**Consultation Response from KC,
 Trees**
2020/93308 Former Spotted Cow Pub, New Hey Road, Huddersfield, HD3 4BU
Erection of an A1 foodstore with associated parking, servicing areas and landscaping
Date Responded: 17/11/20
**Responding Officer: Nick
 Goddard**
Responding Ref: 61/92

PROJECT	Lidl Store New Hey Road, Huddersfield			
DRAWING TITLE	Retaining Wall Sections

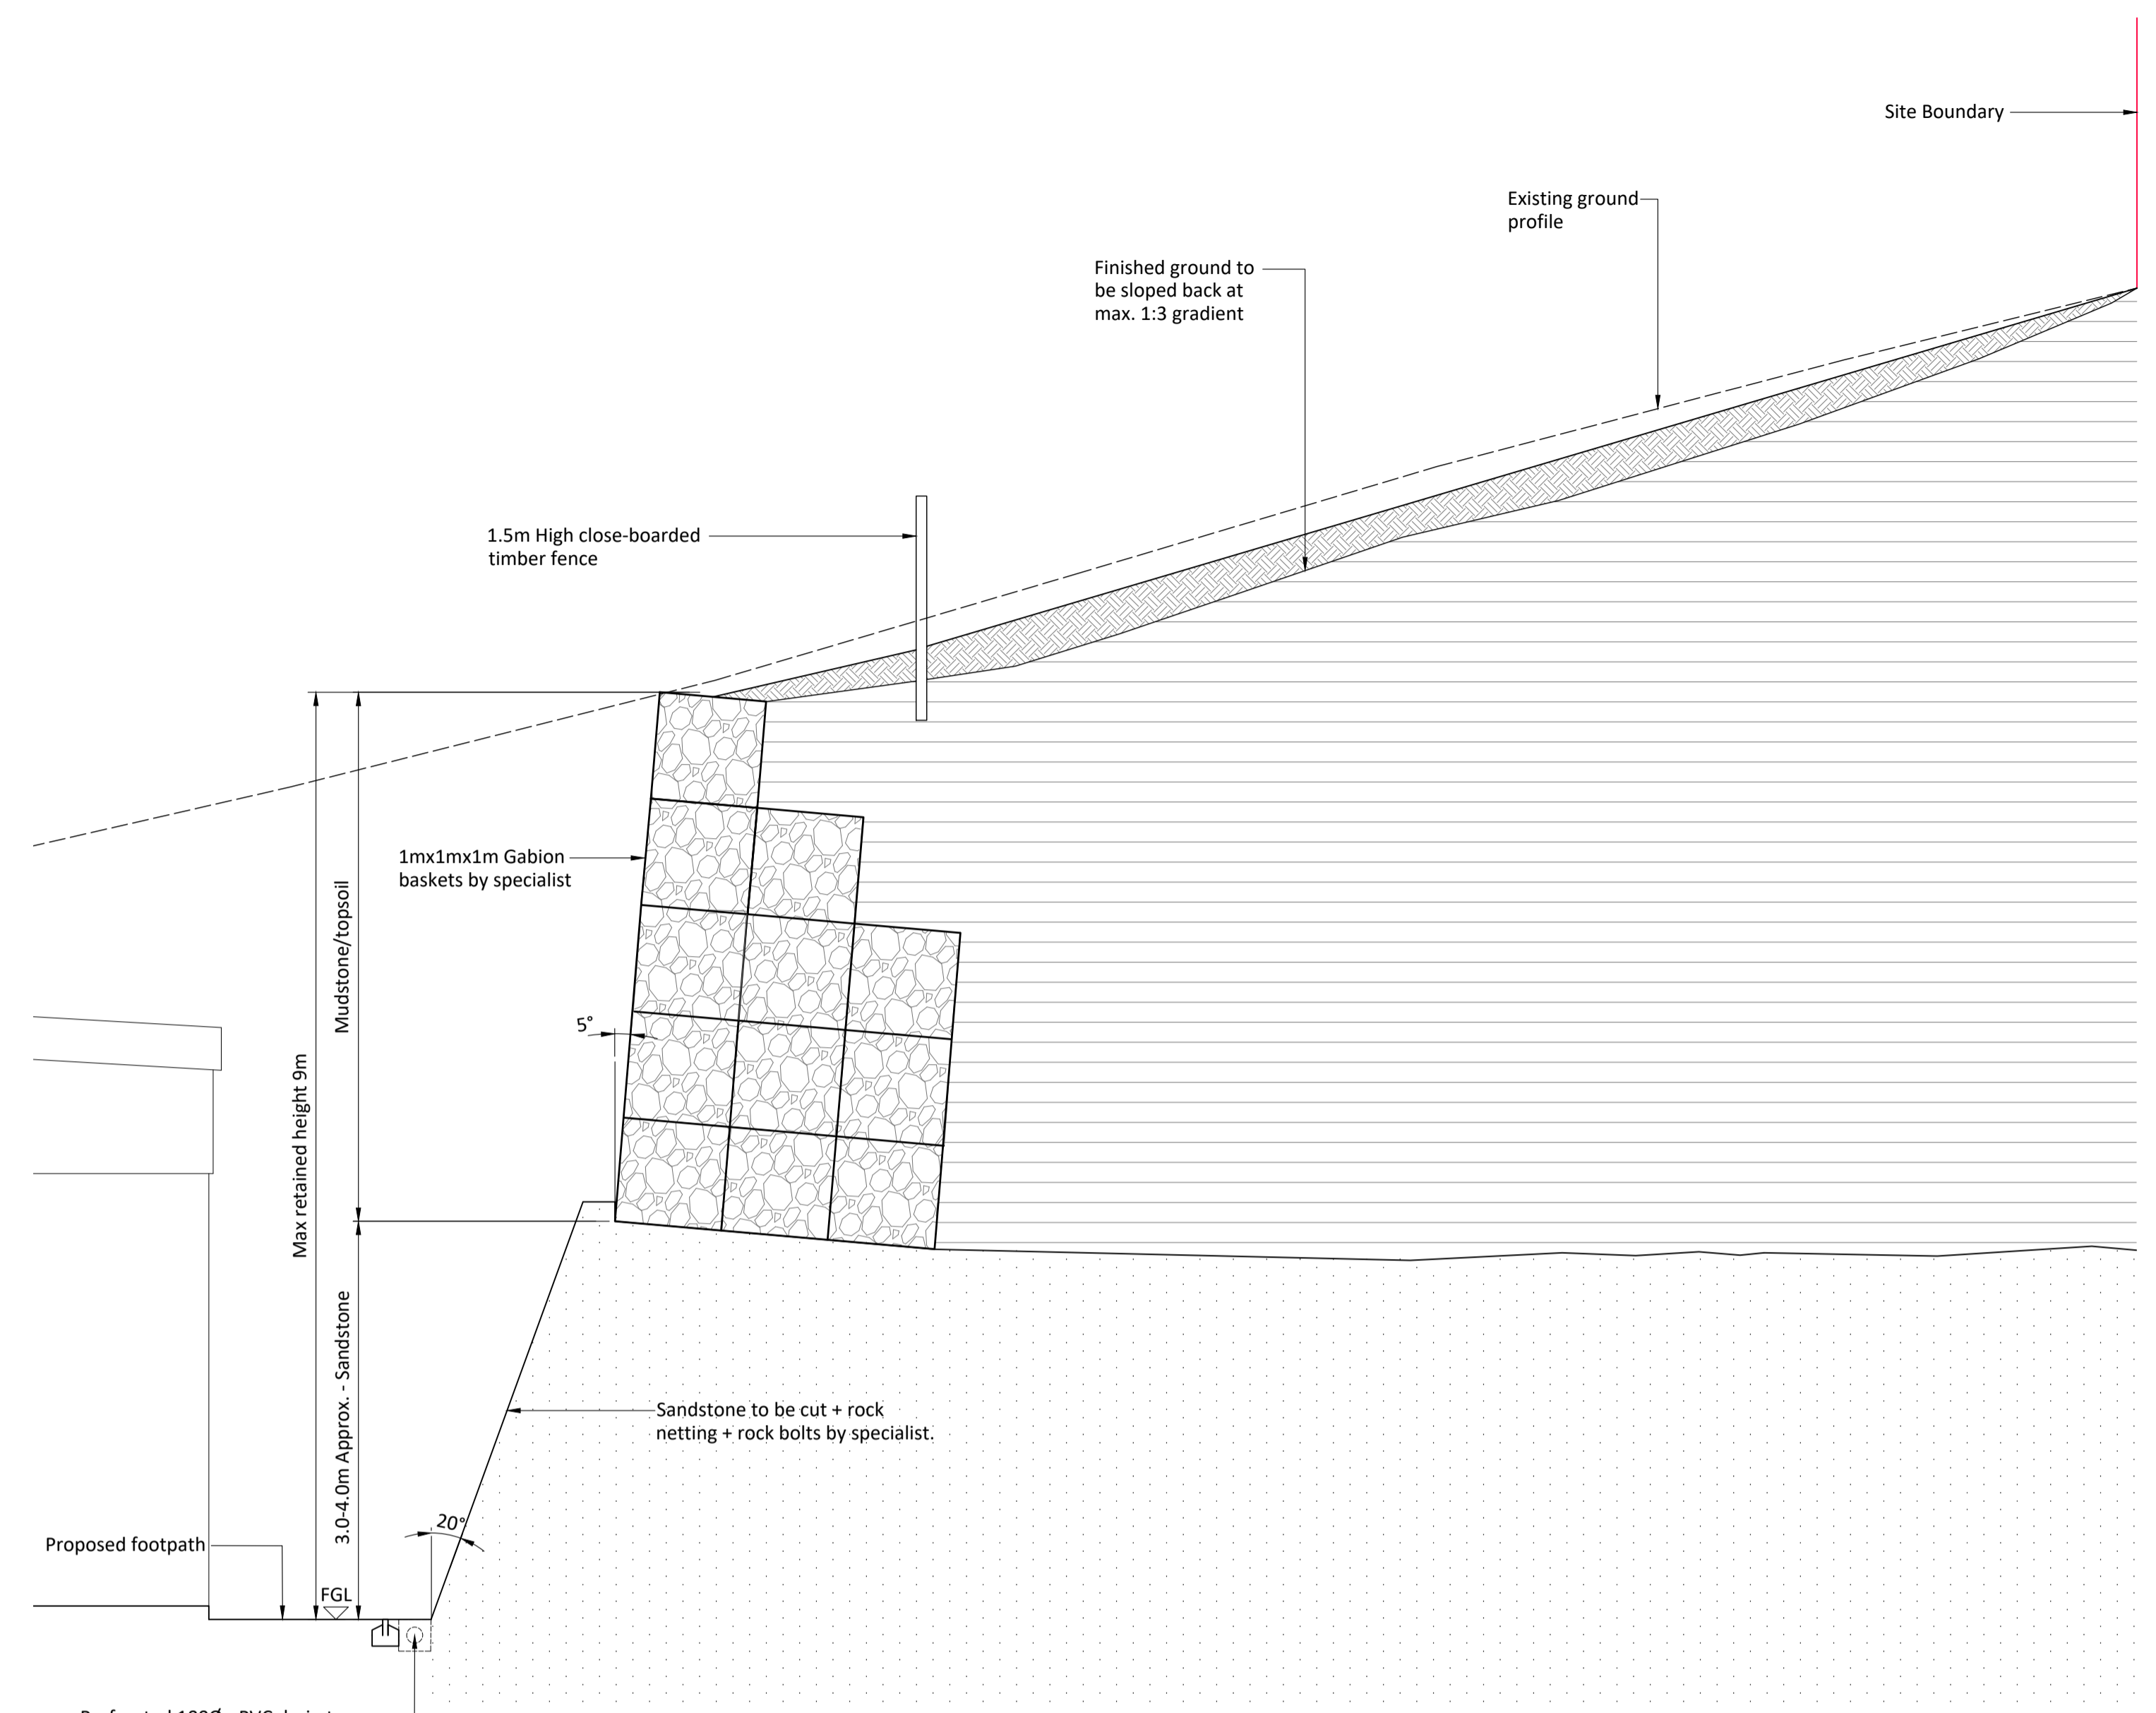
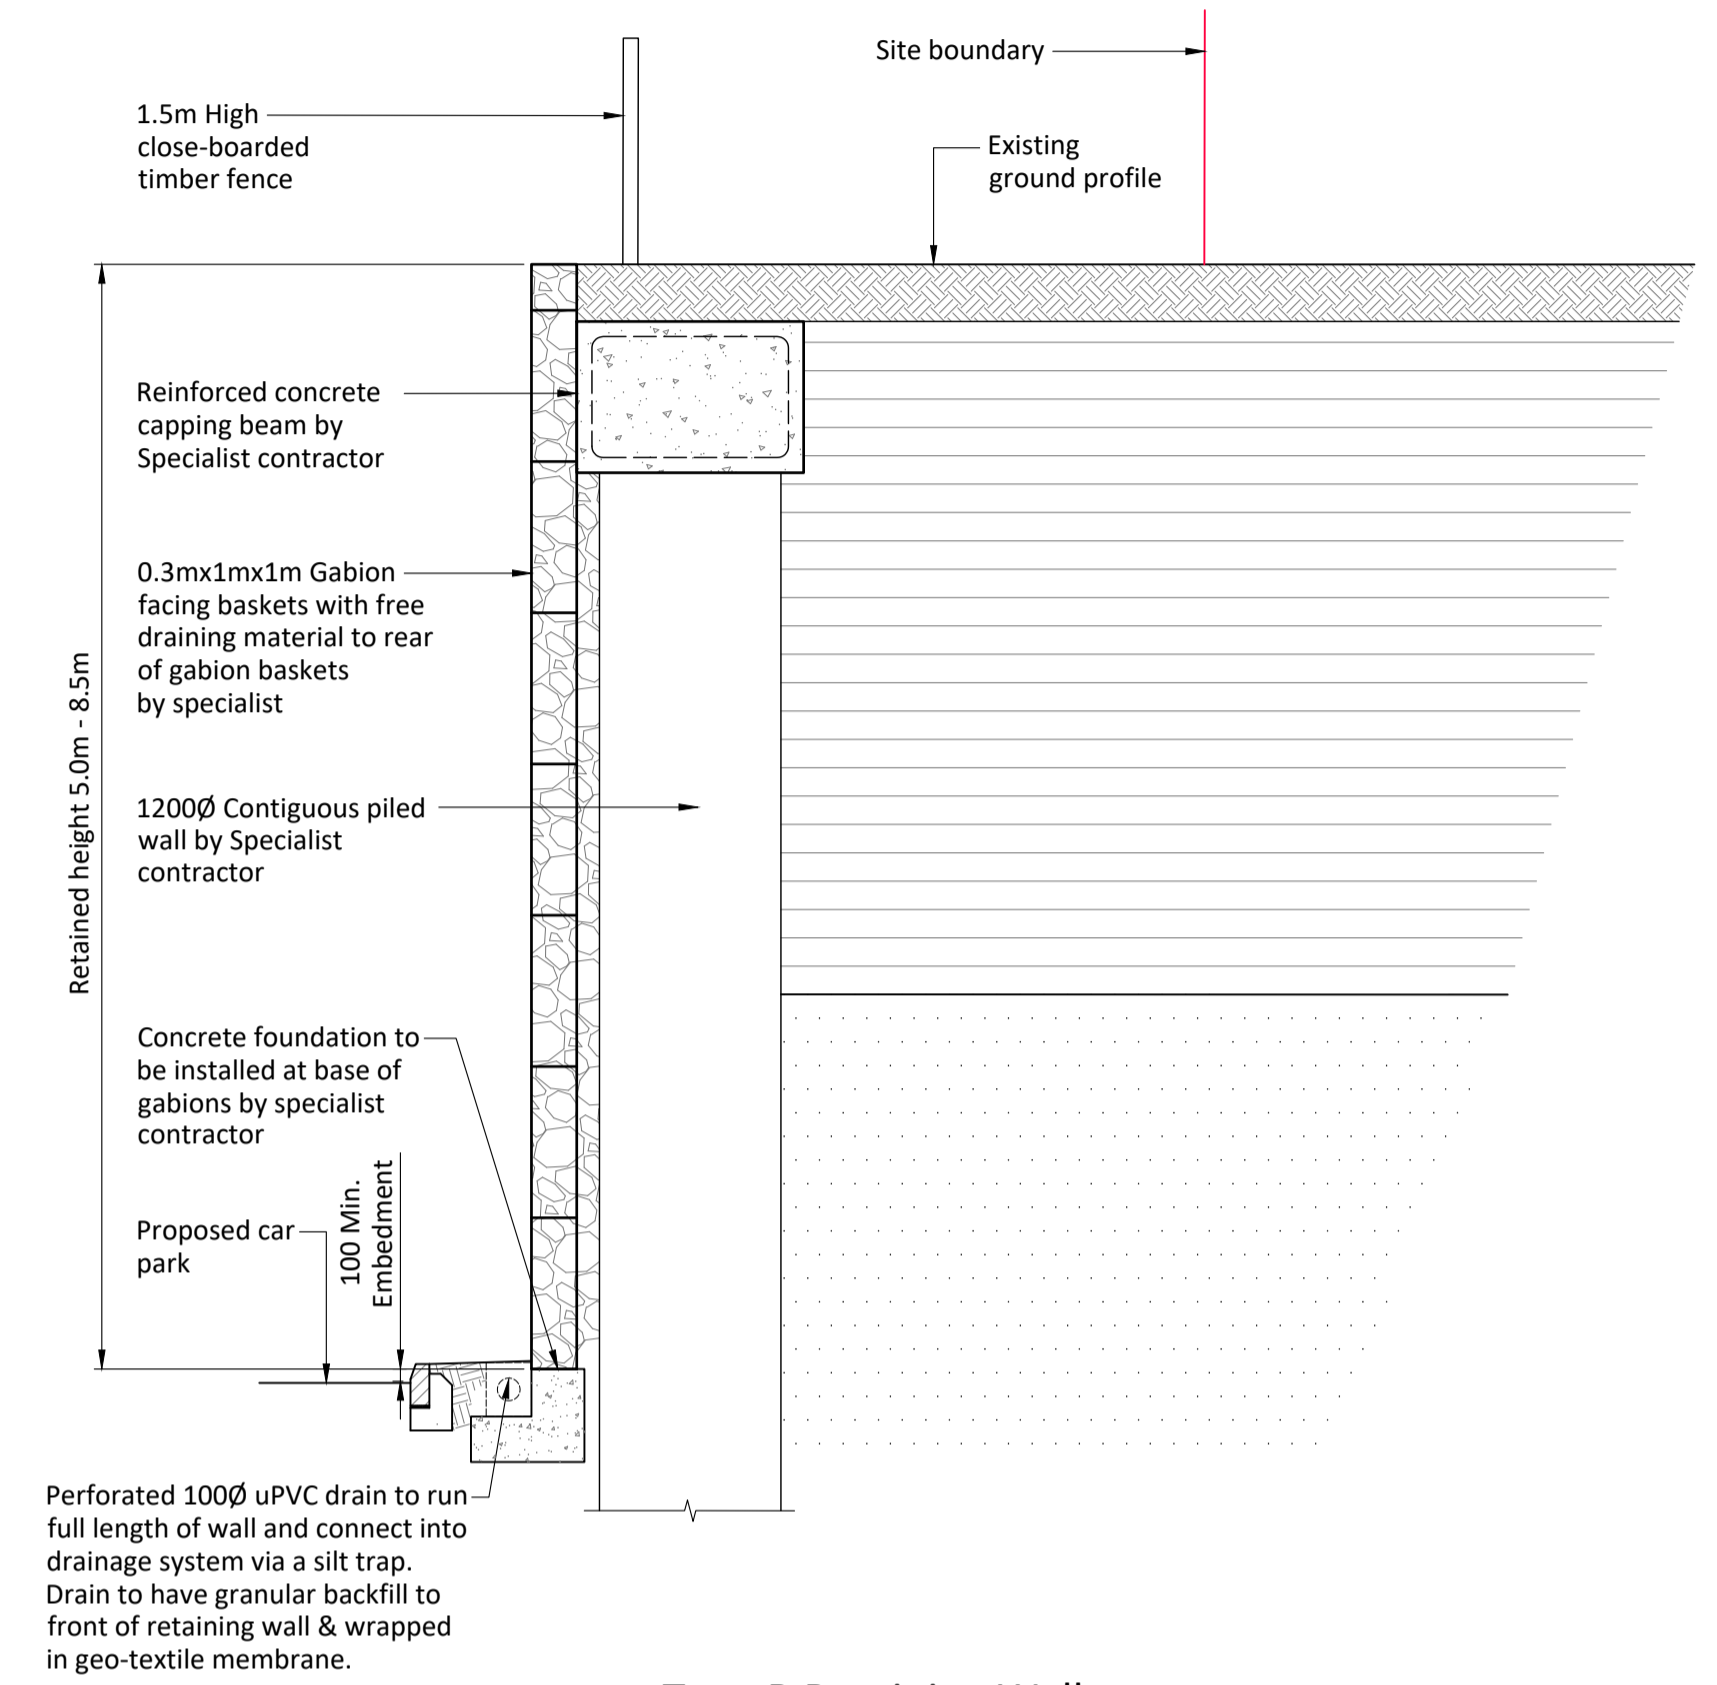
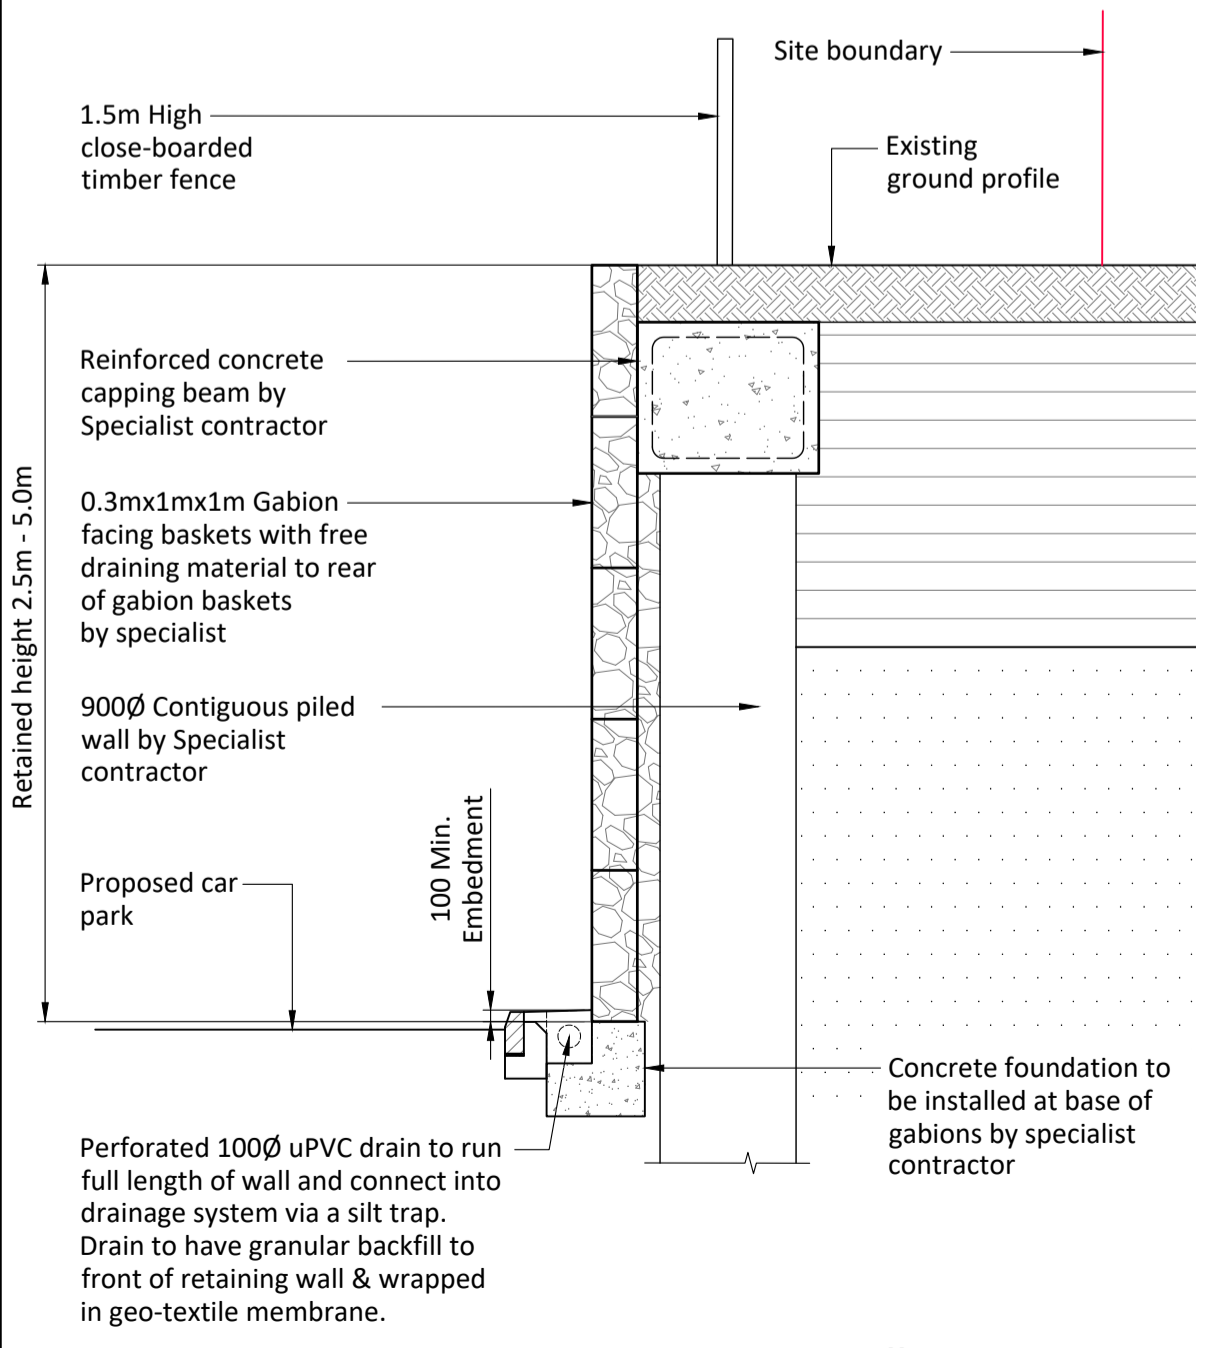
The Boundary Treatments Site Plan, shows that there is to be sheet piling and a gabion wall installed along the edge of the loading area and within the RPA of G13. The retaining wall is between 1-1.5m tall and in places is within 6m of the protected trees. There is also to be an acoustic fence installed along the site's north-western boundary which at its western end will be within the RPA of G13 and within 1m of the stem of the end tree in this group, no details of this installation within the RPA have been provided.

It is a similar question regarding the parking bay at the eastern end of the RPA of G13. To construct this required a 0.5m high retaining wall and sheet piling, all within the RPA. Given the other infringements proposed to the RPA of these trees can this parking bay not be dropped from the plans; doing so would afford much more space around the tree and give more room for the lighting column.
